Modification of Development Consent

Development Consent: SSD 8606 granted by the A/Executive Director, Key Sites and Industry Assessment, on 16 August 2018

Modification Application: SSD 8606 MOD 2

Land: Hollinsworth Road, Blacktown
Lot 23 DP 262886
Lot 24 DP 262886

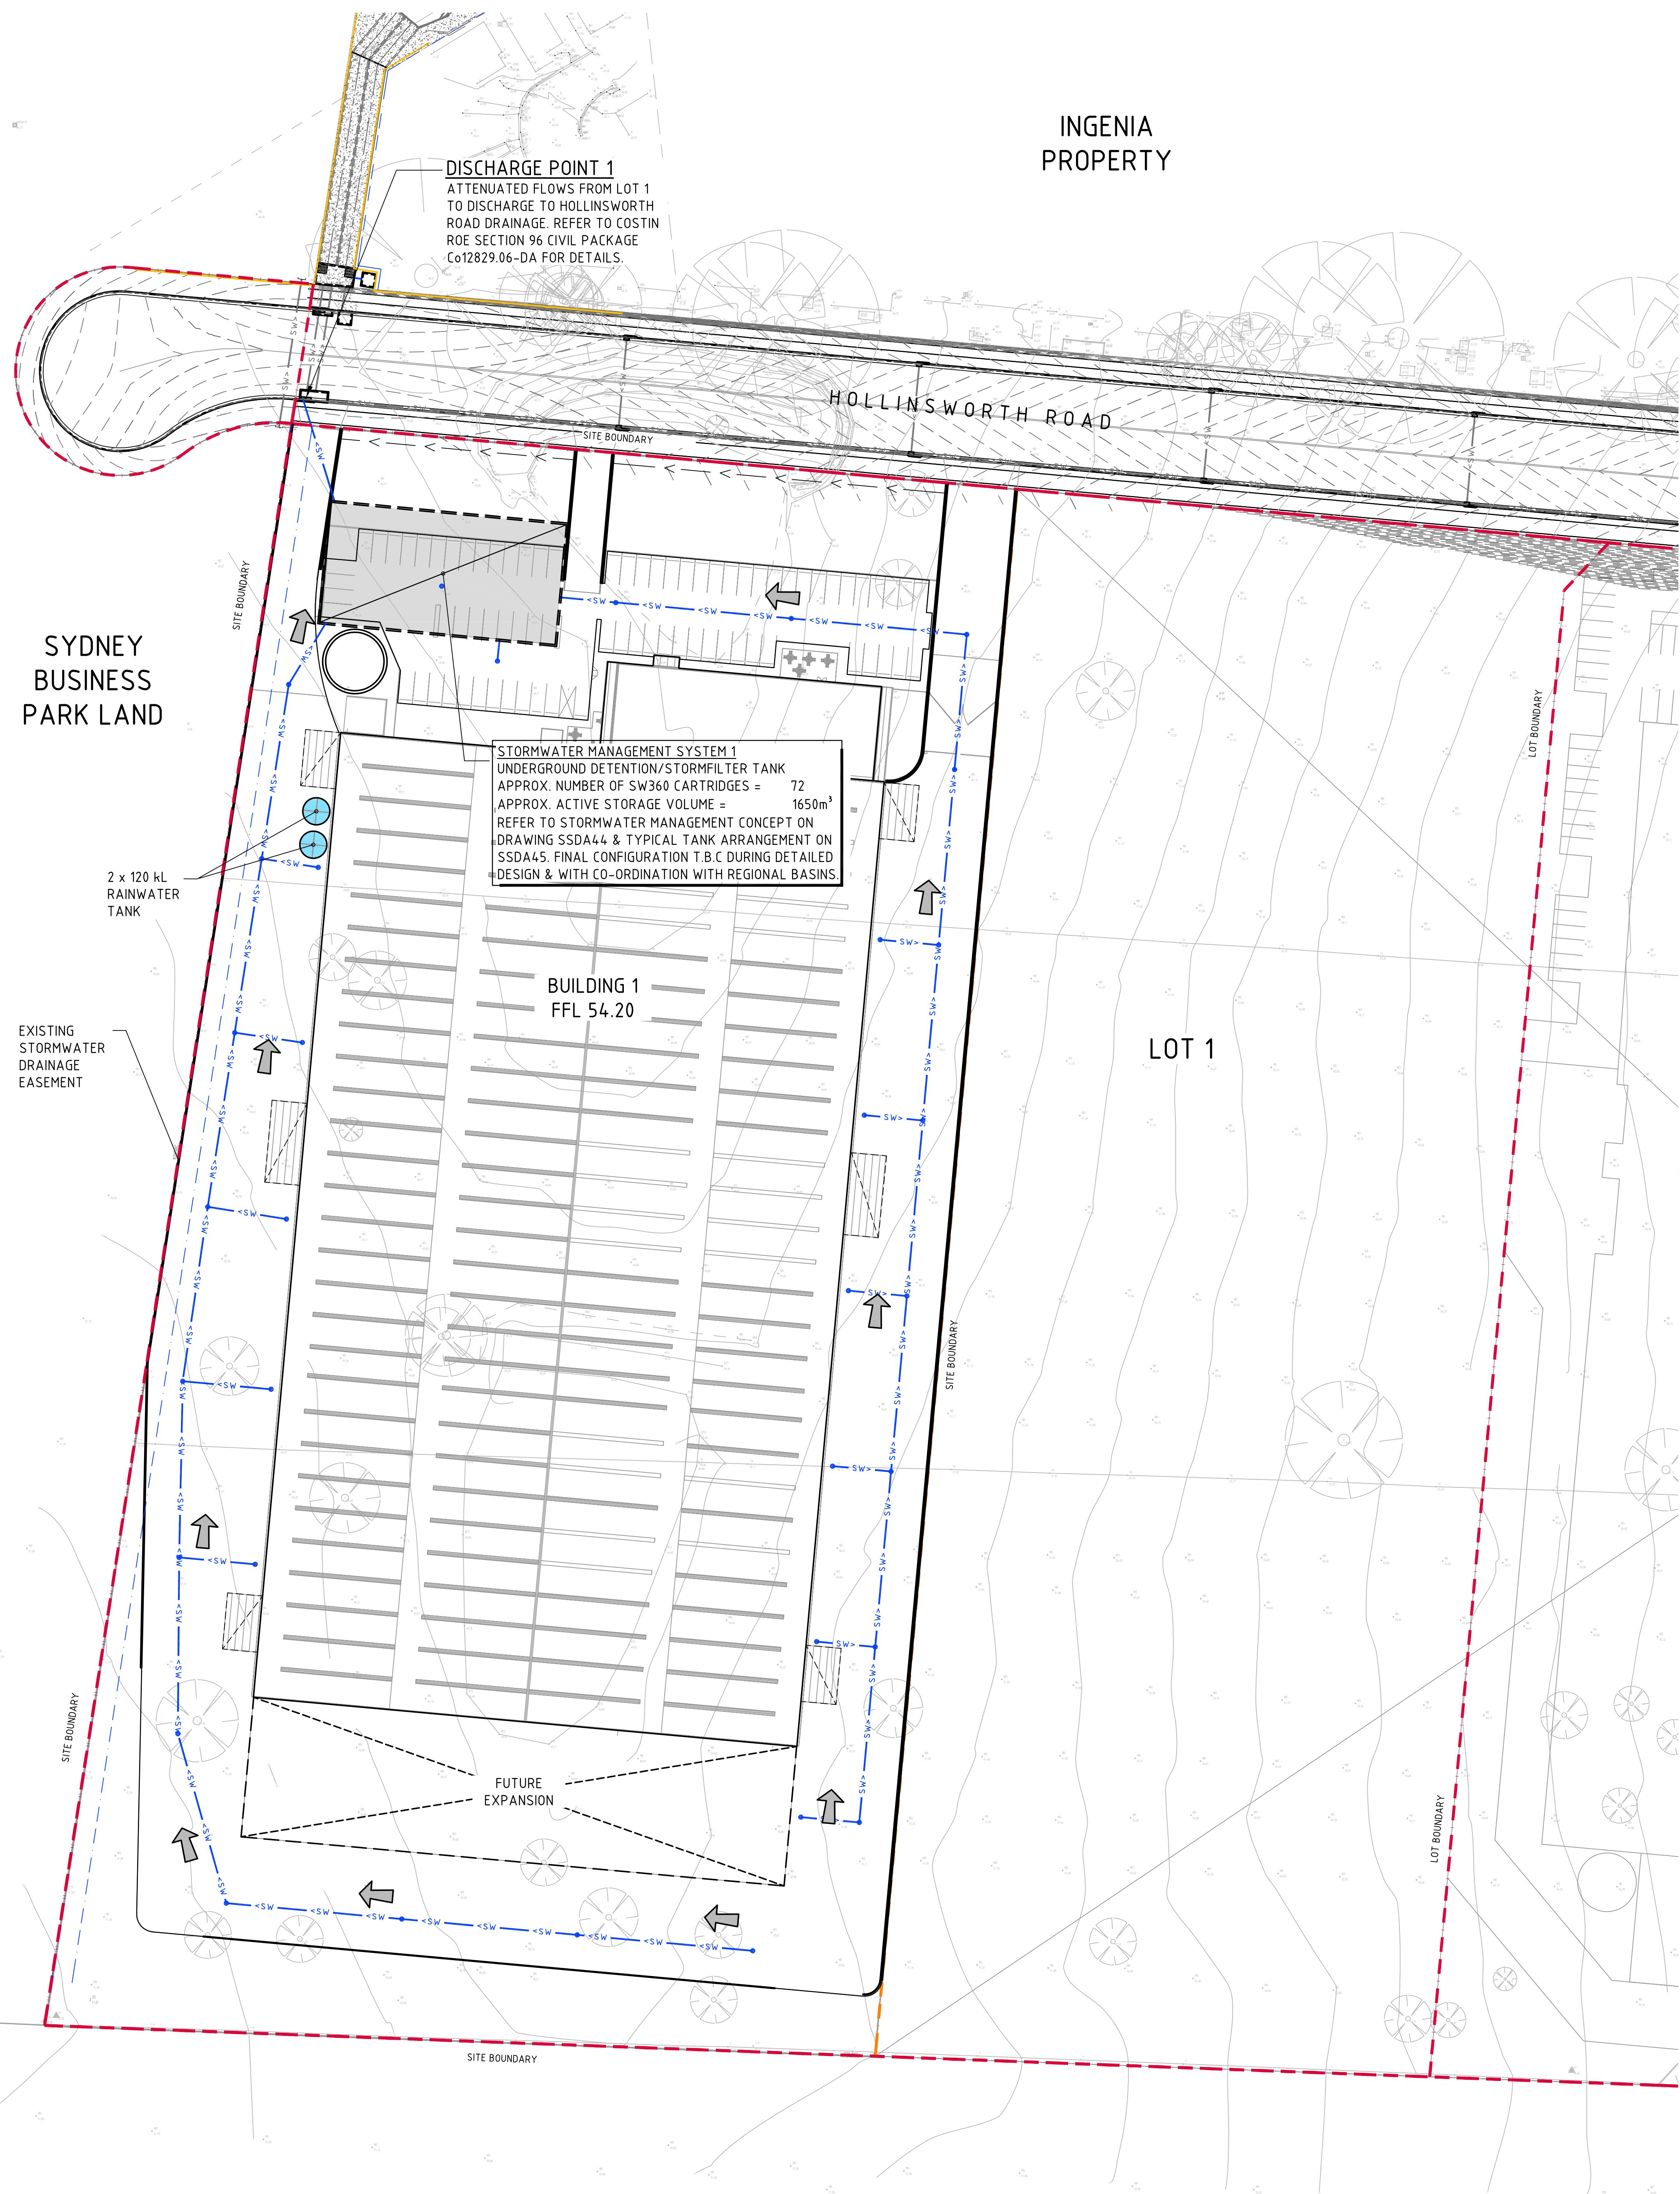
B30. The Applicant must install rainwater harvesting systems for each warehouse building in accordance with the Concept Stormwater Management Strategy show in plan Co12829.06-SSDA44, issue B, dated 29.08.2019 to achieve rainwater re-use of a minimum of 80% for non-potable uses.
5. Delete Condition B36 and replace with:
